**SECTION 96(1A) MODIFICATION APPLICATION - SSD 6513
BUILDING R1, BARANGAROO SOUTH**

On behalf of Lendlease (Millers Point) Pty Ltd, we hereby submit an application pursuant to Section 96(1A) of the *Environmental Planning and Assessment Act 1979* ('EP&A Act') to modify State Significant Development Application ('SSDA') SSD 6513 relating to Building R1, Barangaroo South ('the site').

The modification (Modification 2) proposes minor design amendments at the ground level and at the rooftop/plant room, in response to the design development of Building R1. These amendments do not impact on the built form, scale or aesthetics of the development and will not affect access from the public domain. These design development changes are ordinary and expected in substantial projects for new buildings. The development, as proposed to be modified, will remain substantially the same as approved.

drawing title
Plant Room Roof Plan

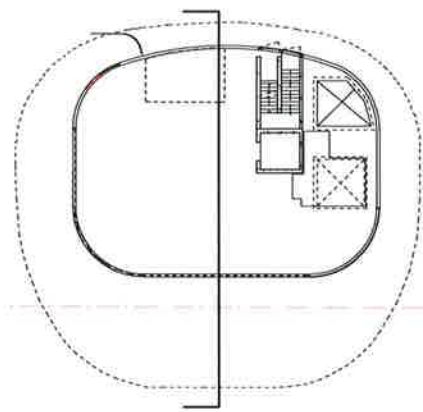
- relocation of a ground level entry door along the eastern elevation;
- alteration of handrails associated with stairs at ground level along the southern boundary;
- reconfiguration of the services exhaust cladding above the rooftop plant room;
- greater emphasis of the plant room door to be concealed behind a continuous cladding finish;
- revised rooftop plant room cladding; and
- revised handrail at rooftop from a raking to vertical design.
